**50 Fordgate
Hinchliffe Mill
Holmfirth
HD9 2NZ**

Ref: Planning Application 2021/62/90800

In respect of the above proposed development, I wish to register my objection.

HOUSE TYPE : UNIT 17

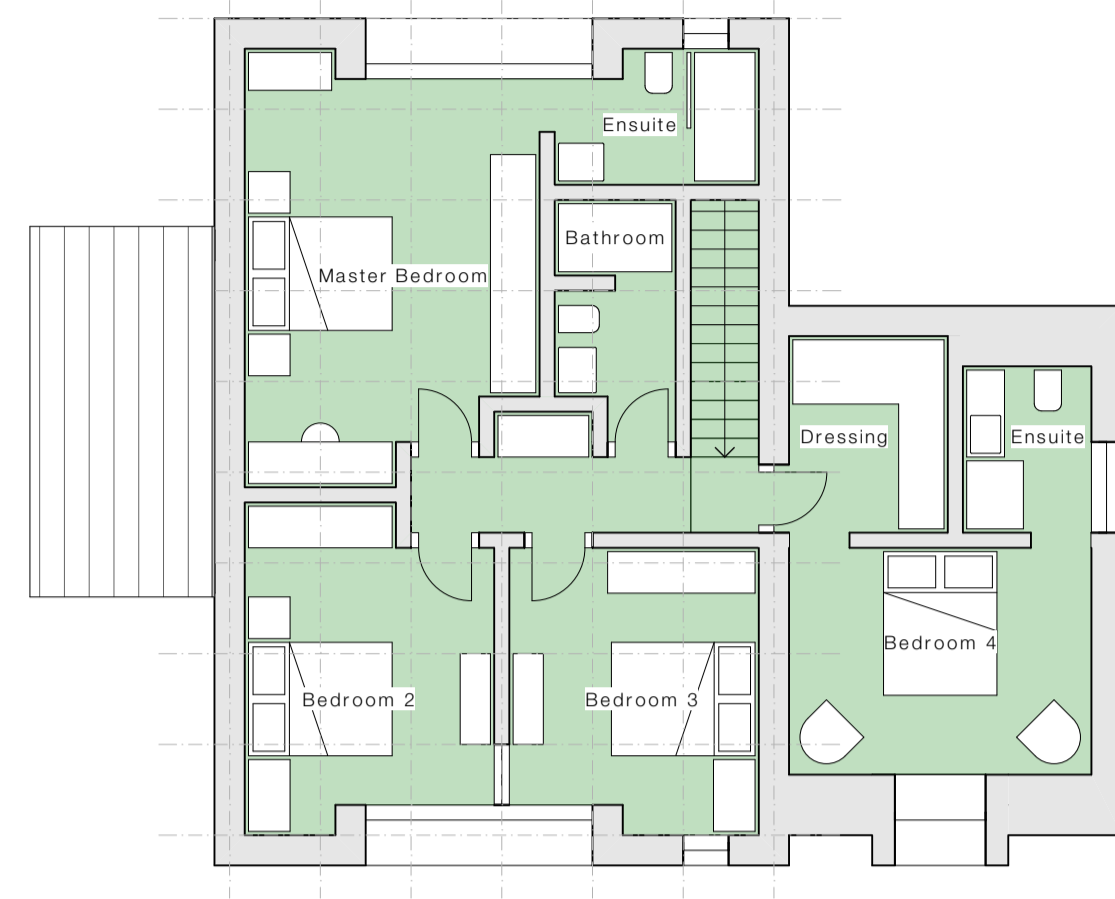
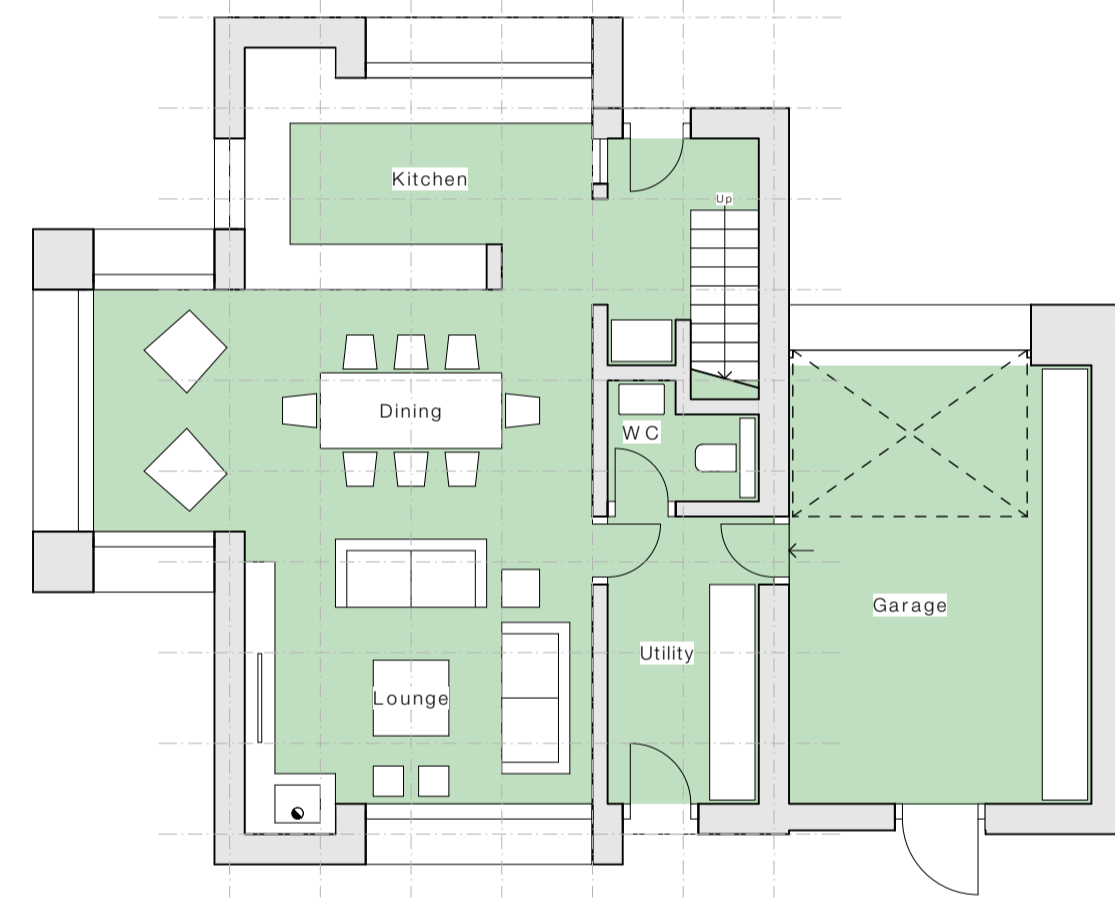
- 6) I strongly object to the proposed buildings, plots 17,18 and 19 on the site plan. Being located in an elevated position and in terms of their size and style, they dominate and detract from the character of the grade 3 listed mill building and degrade the visual amenity of the existing environment. It would appear that they are also proposed to be located on green field land, in contravention of current policies.**
